# Rolling Hills Ranch North PUD Transportation Memorandum (LSC #S234290) October 30, 2023

PCD File  
PUDSP235 <sup>1</sup>

# Summary of Comments on [WORKING] RHRN TIS - 1RESPONSES With Tom edits.pdf

Figure 3 School Pedestrian Routes from the Rolling Hills Ranch PUDSP
Traffic Impact Analysis

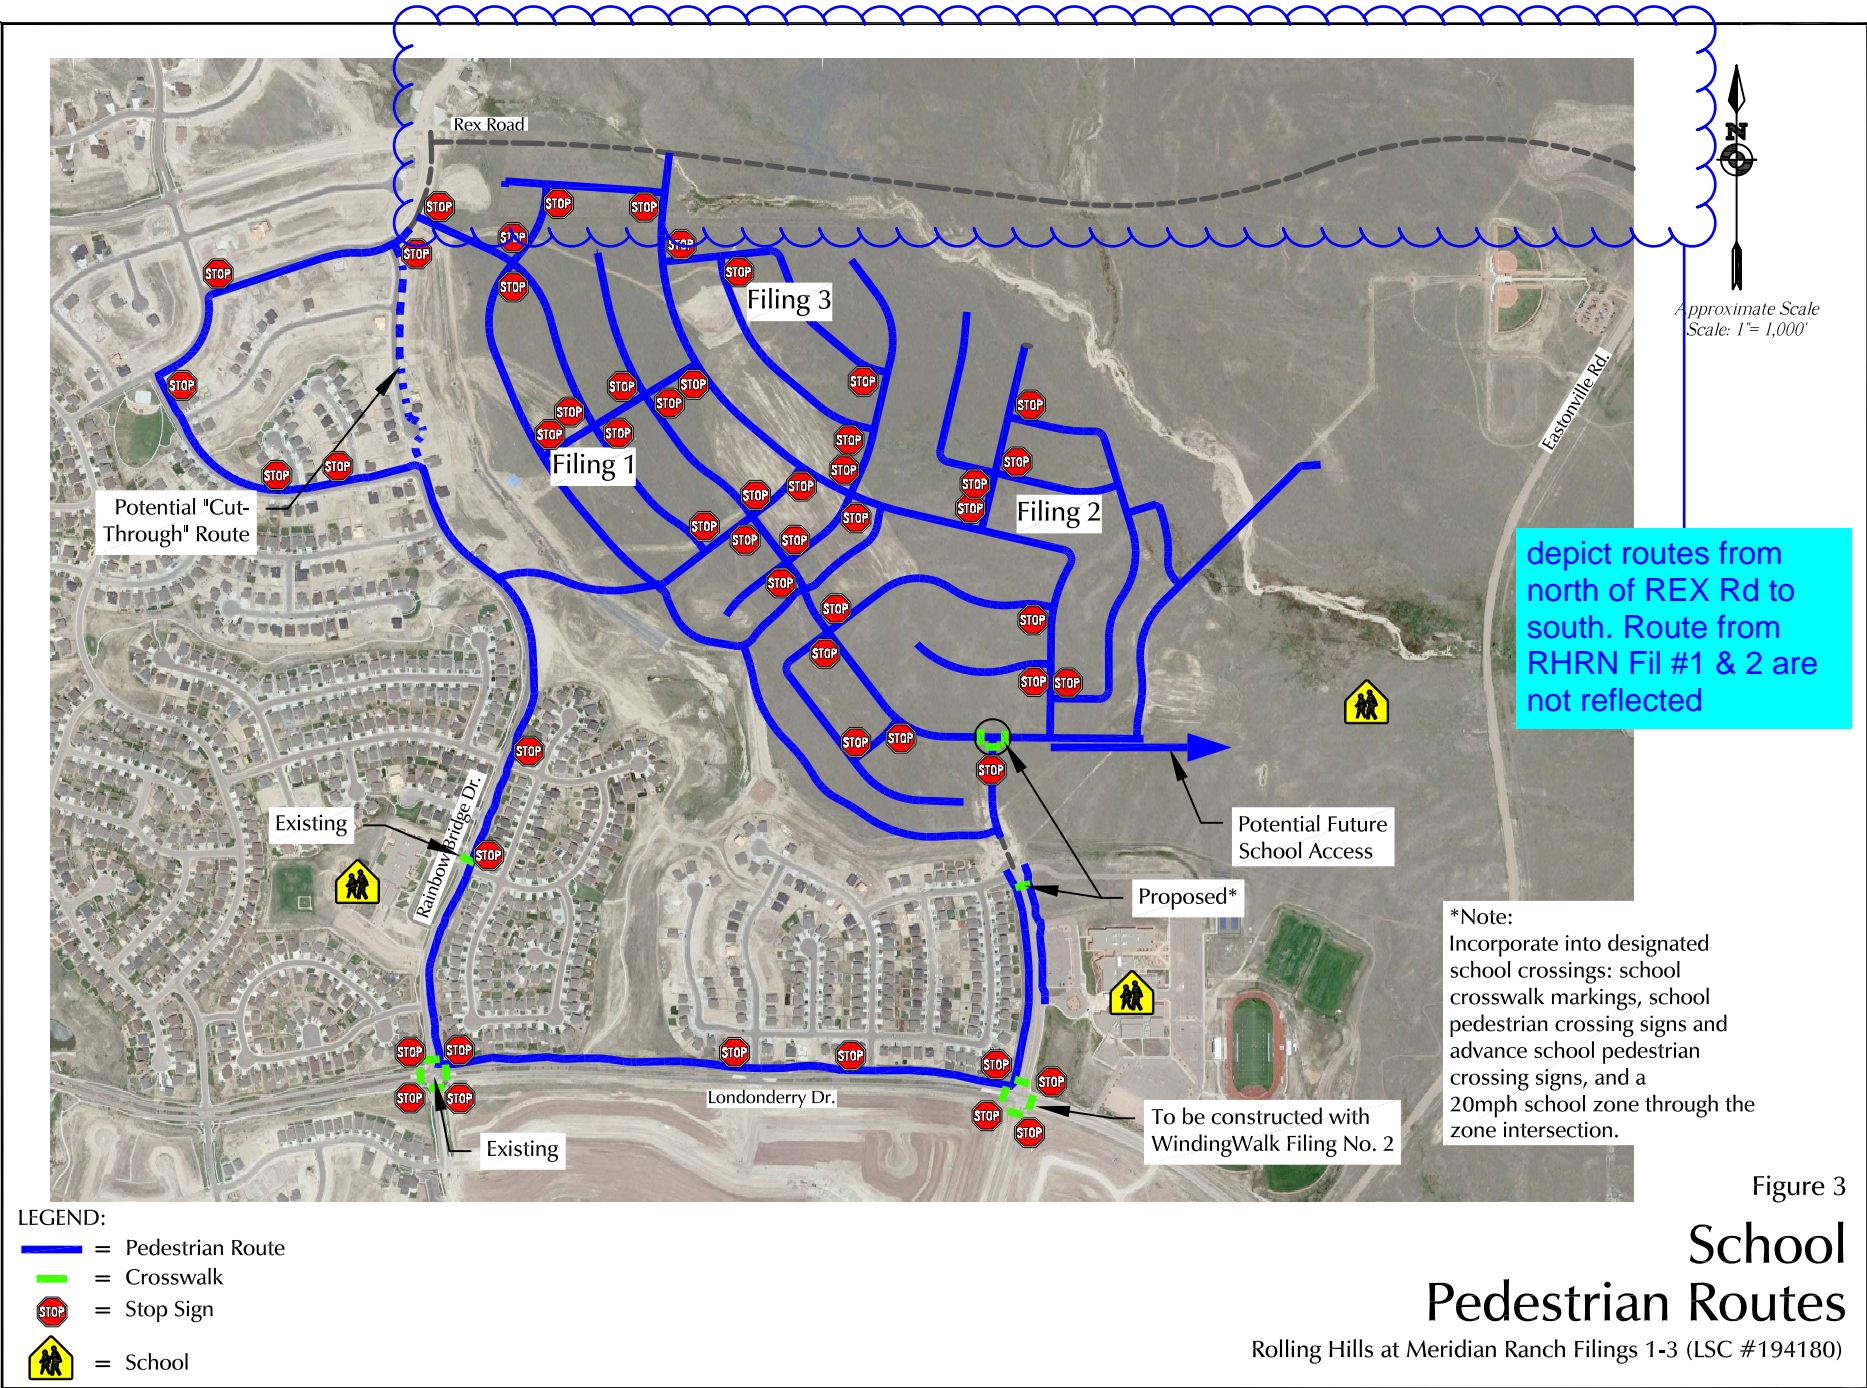
[Is this PED crossing marked?](#)

LSC Response: An updated pedestrian plan has been included in the updated TIS.

Figure 4  
**Sight Distance Analysis**  
**Rex/Shelter Creek**

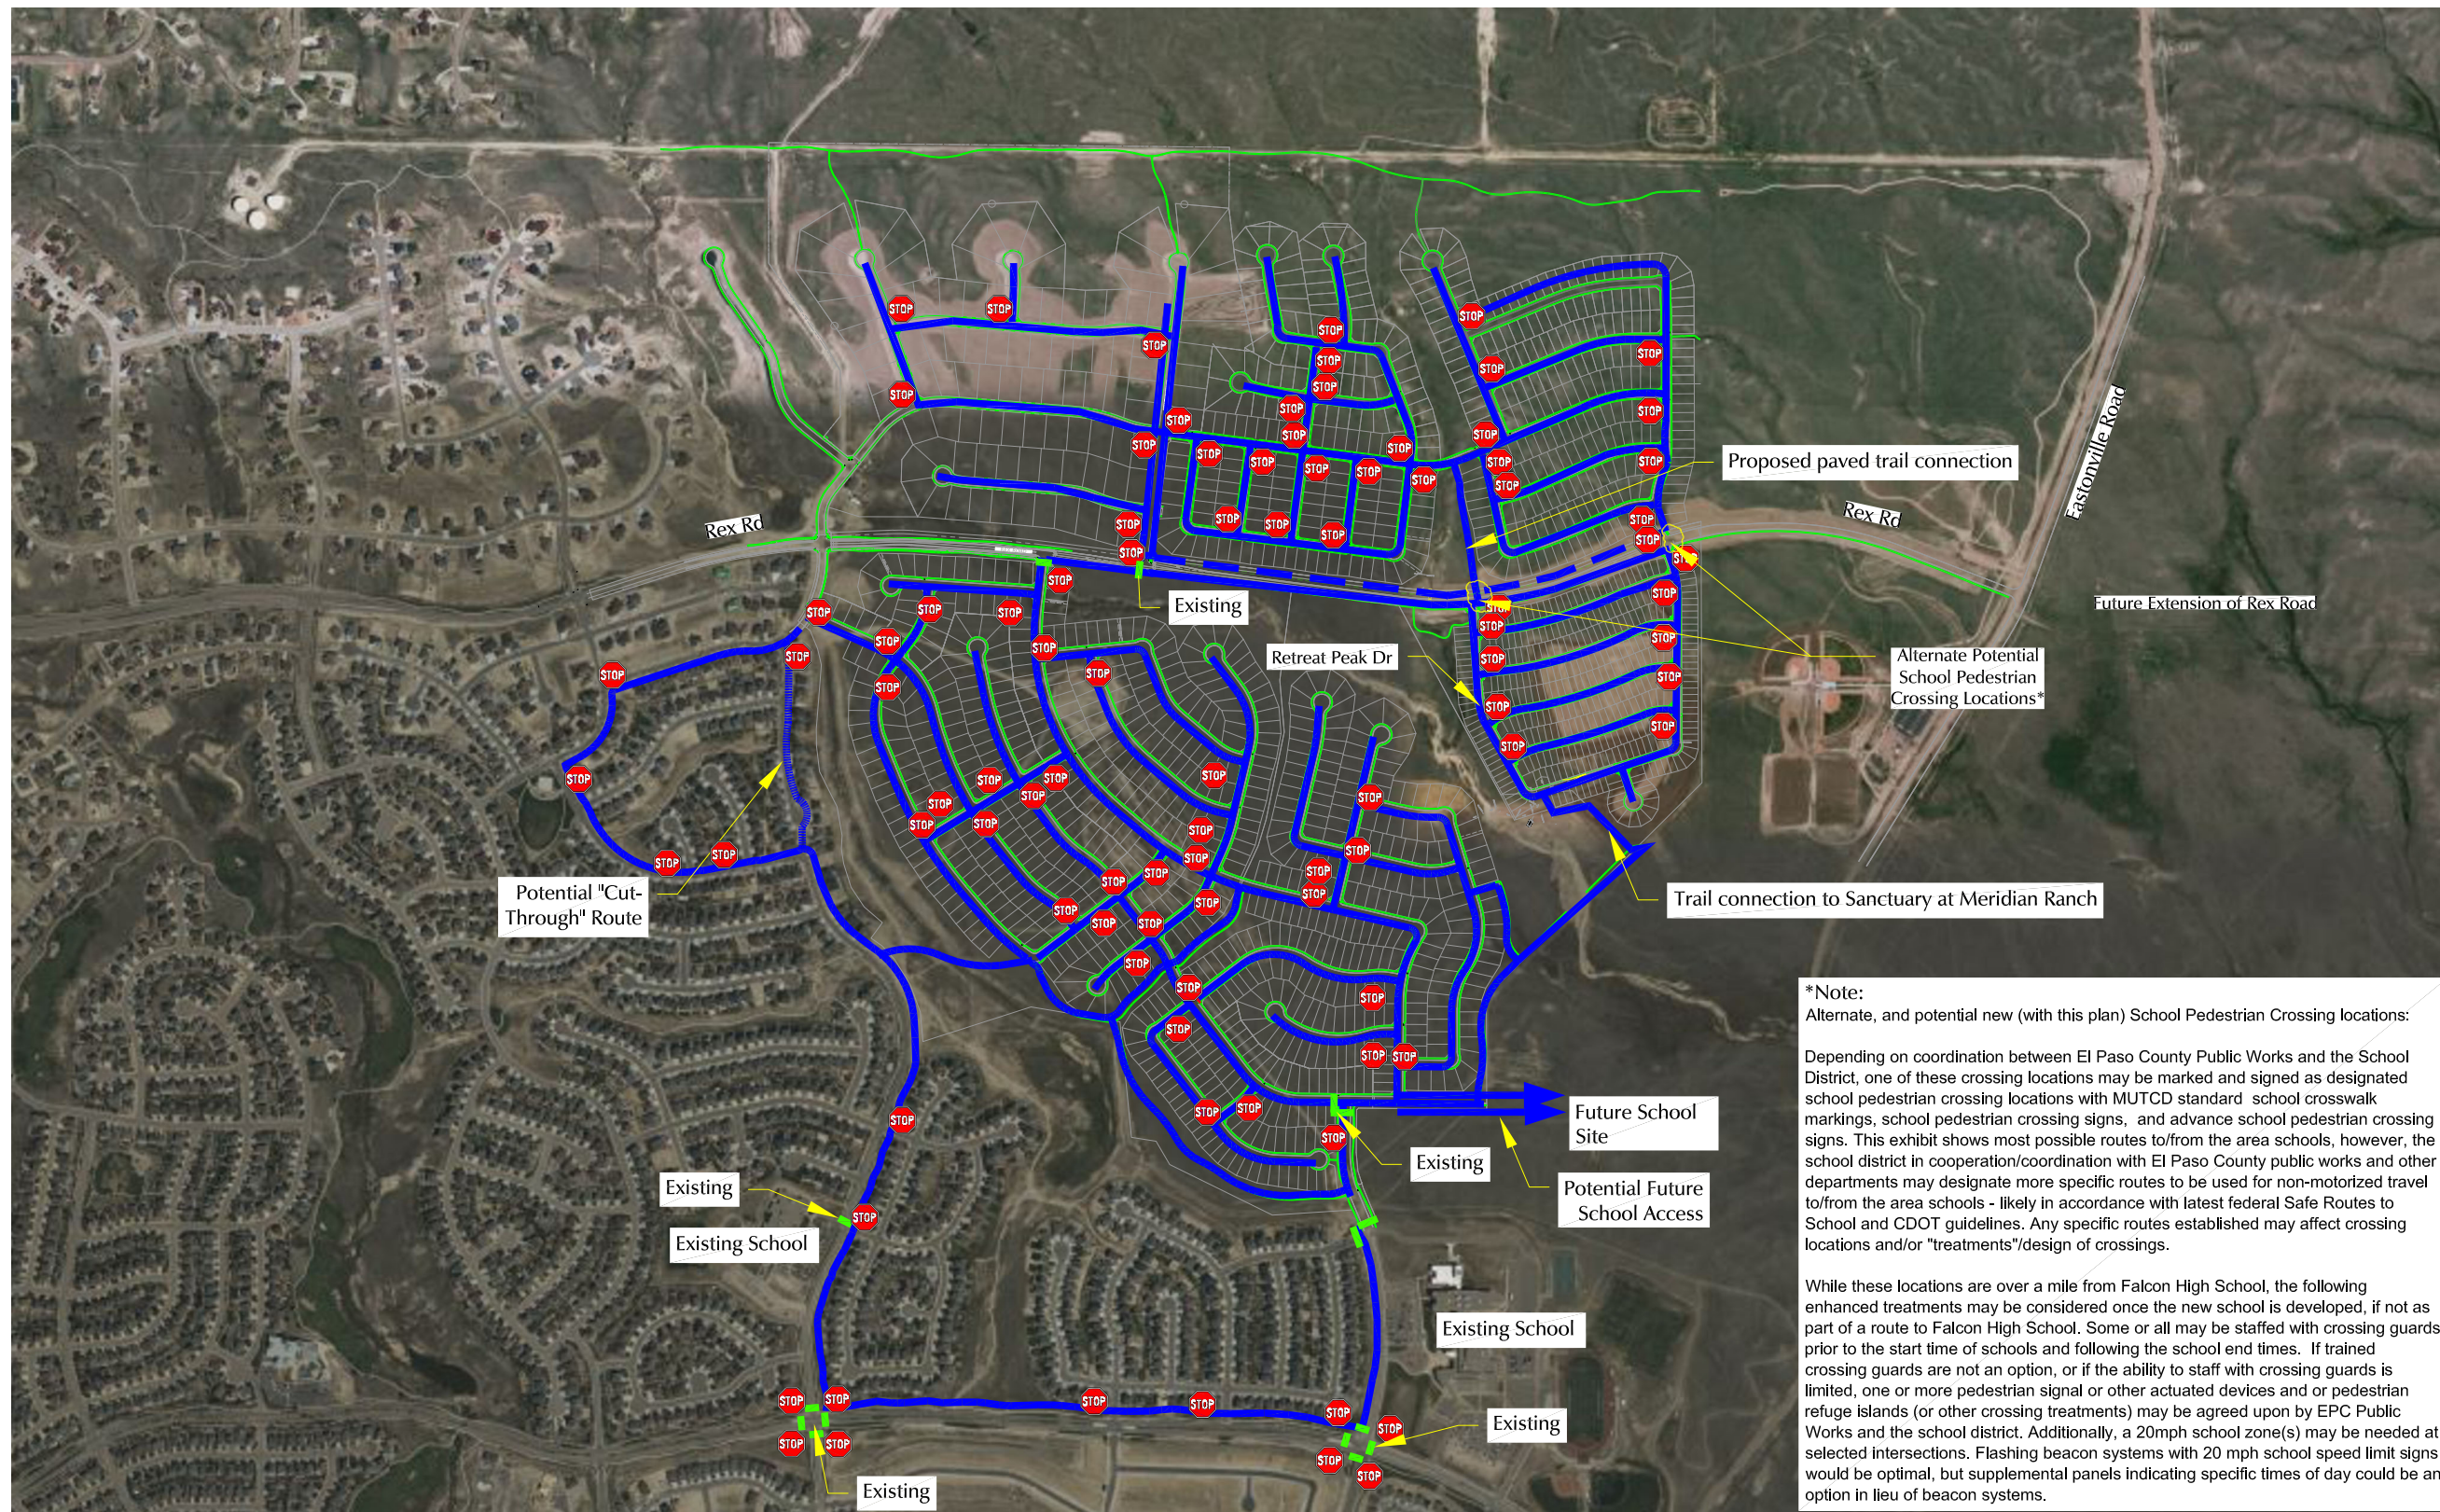
depict routes from north of REX Rd to south. Route from RHRN Fil #1 & 2 are not reflected

depict eastern access routes and label intersections with Rex Rd and streets. The school route from the east is unclear

LSC Response: An updated pedestrian plan has been included in the updated TIS.

LSC Response: An updated pedestrian plan has been included in the updated TIS.
